**REQUEST**

Current Zoning: N1-A ANDO (Neighborhood 1-A, Airport Noise Disclosure Overlay)  
Proposed Zoning: N2-A(CD) ANDO (Neighborhood 2-A, Conditional, Airport Noise Disclosure Overlay)

Approximately 15.87 acres located on the east side of Sandy Porter Road, south of Arrowood Road, and north of Steelechase Drive.

The petition proposes to redevelop several properties occupied by single-family dwellings with a community of 194 multi-family attached dwellings.

RZ-1.0

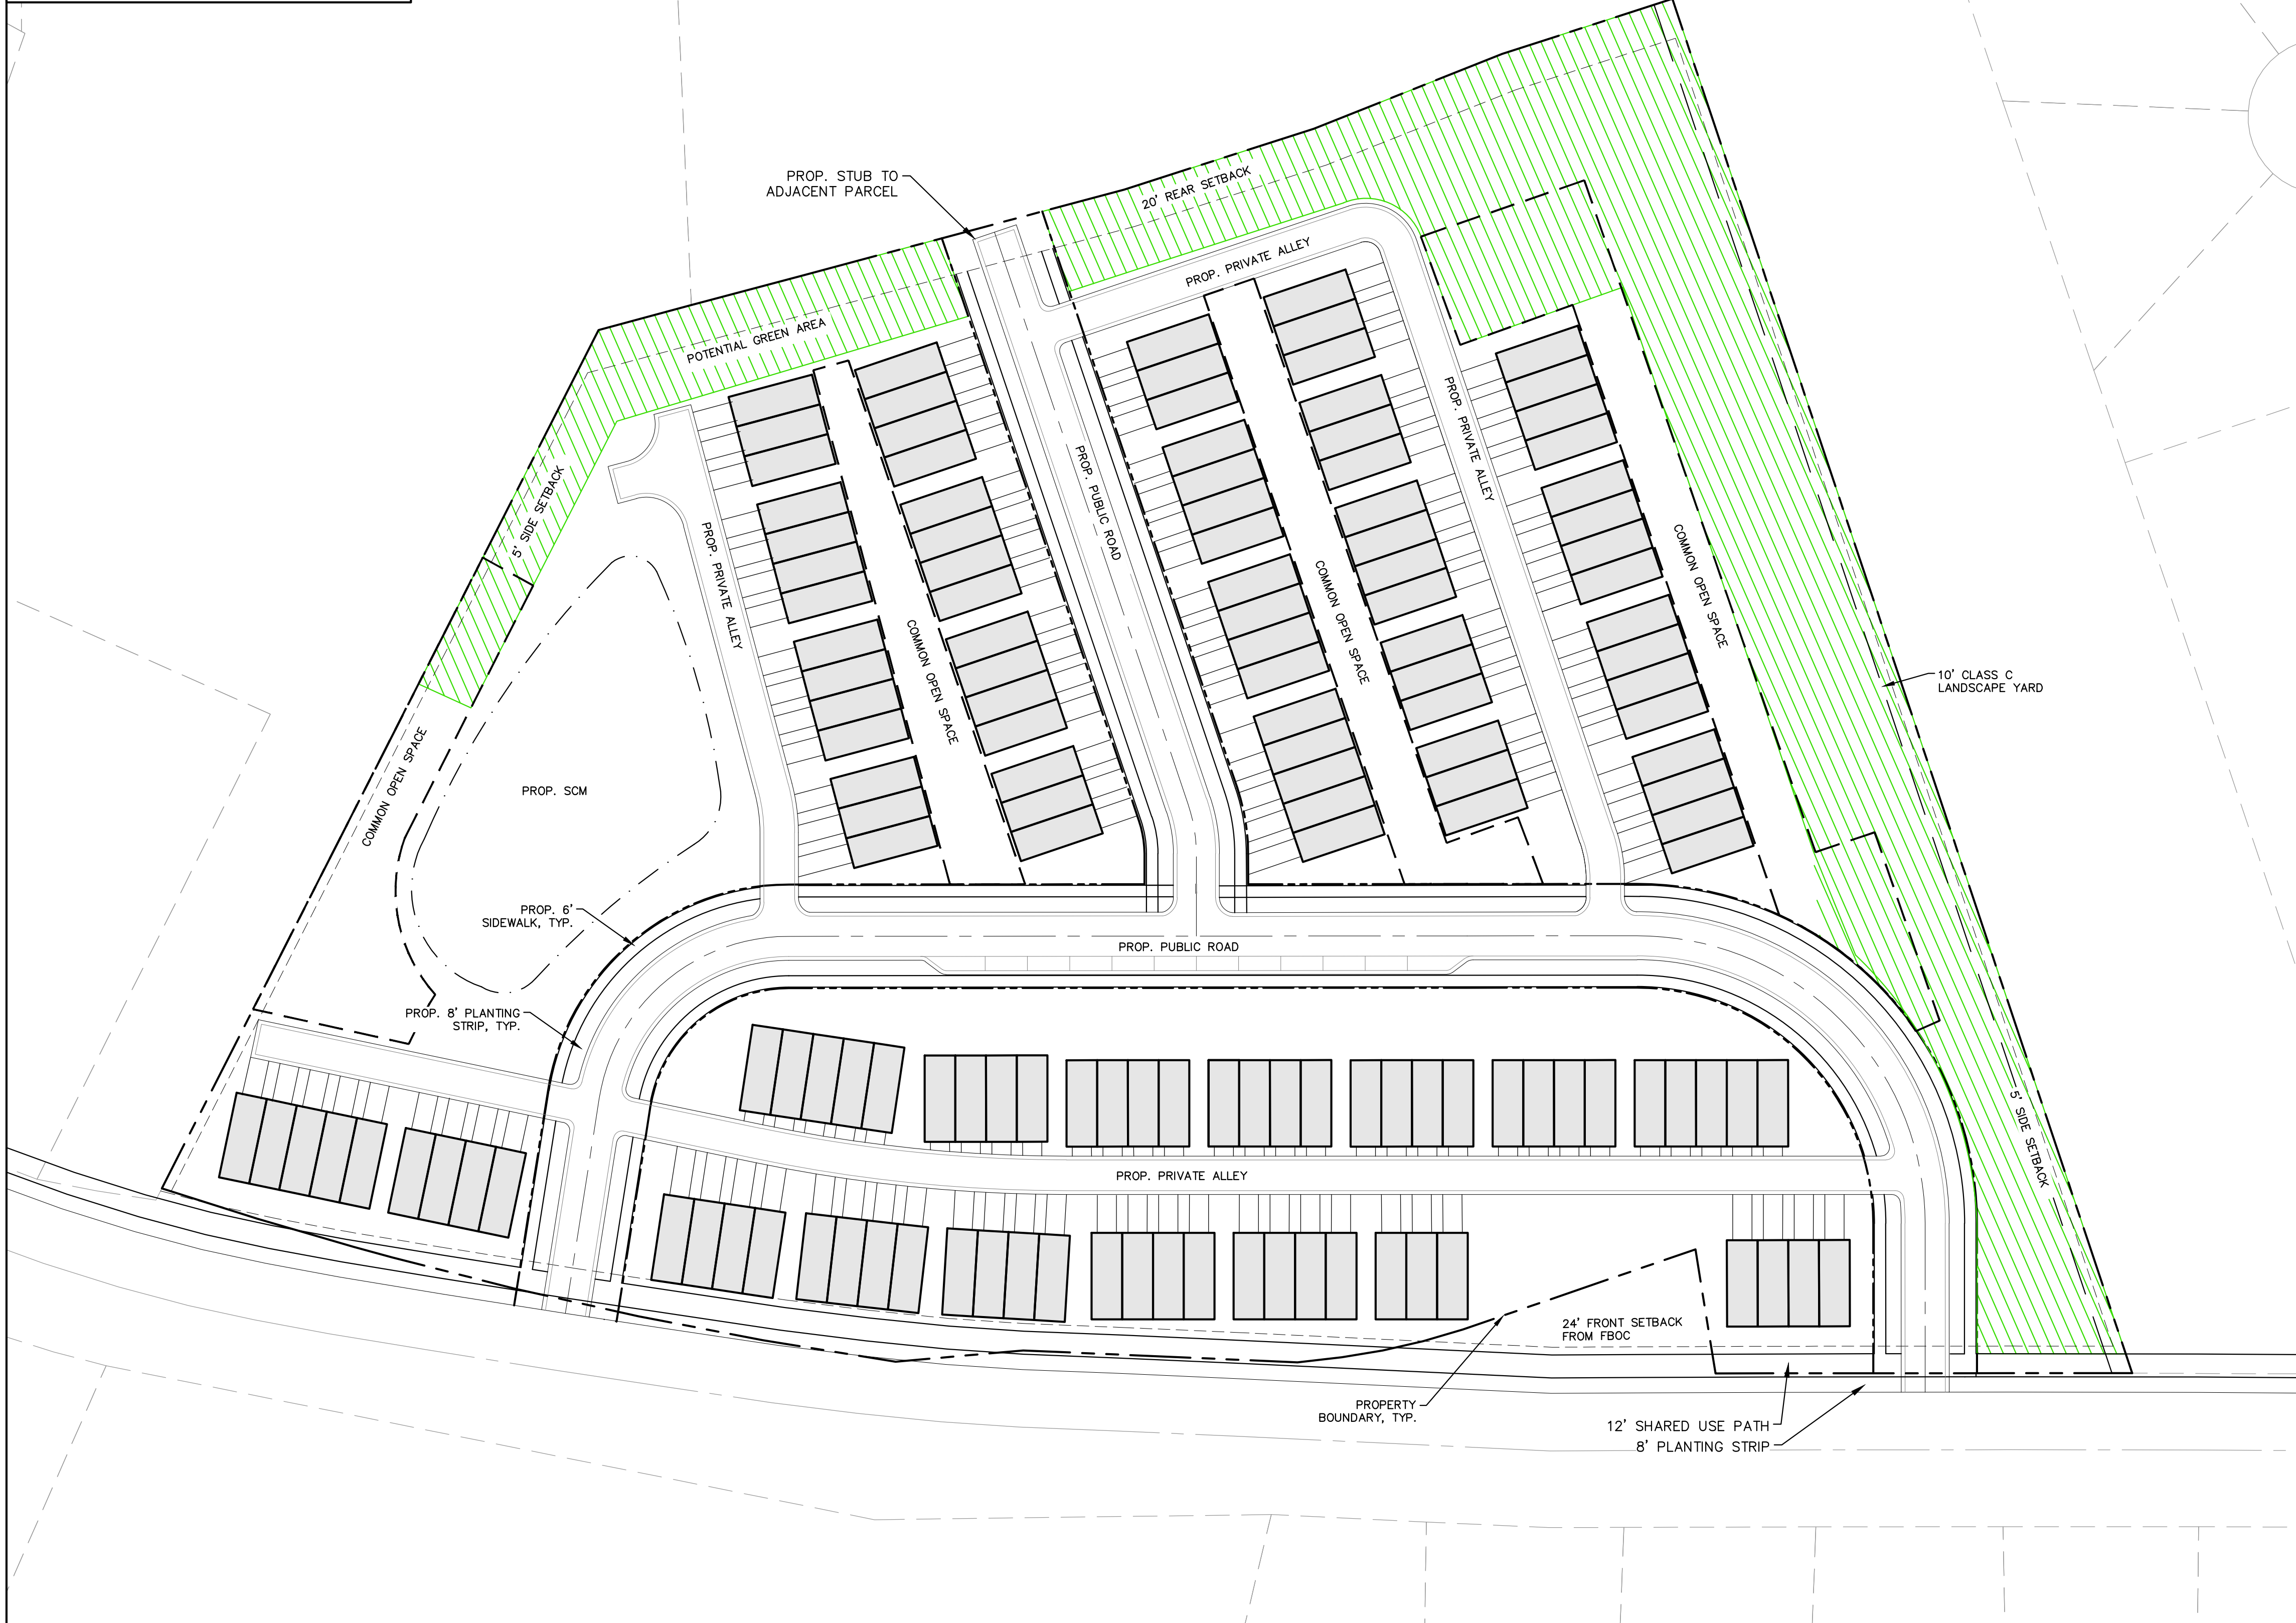
1. Show, dimension, and label in streetscape on all internal public streets. Internal public streets are to be U-03 with 8ft planting strip and 6ft sidewalk and on-street parking. All public streets must have on-street parking where feasible. **OUTSTANDING**
2. Revise site plan to modify right-of-way boundaries as illustrated in the CDOT memo. **OUTSTANDING**
3. ~~Revise the site plan to show existing edge of pavement and all existing striping on Sandy Porter. Site plan should clearly show lane configurations along Sandy Porter adjacent to the project and how the project will tie in at either end of the project. **ADDRESSED**~~
4. ~~Revise Transportation note 11 to correct "rights of way" type. **ADDRESSED**~~

5. Green area must be comprised of existing tree canopy. Most of the southern area does not have existing canopy or the canopy is from trees on the adjoining property that cannot be used. **OUTSTANDING**
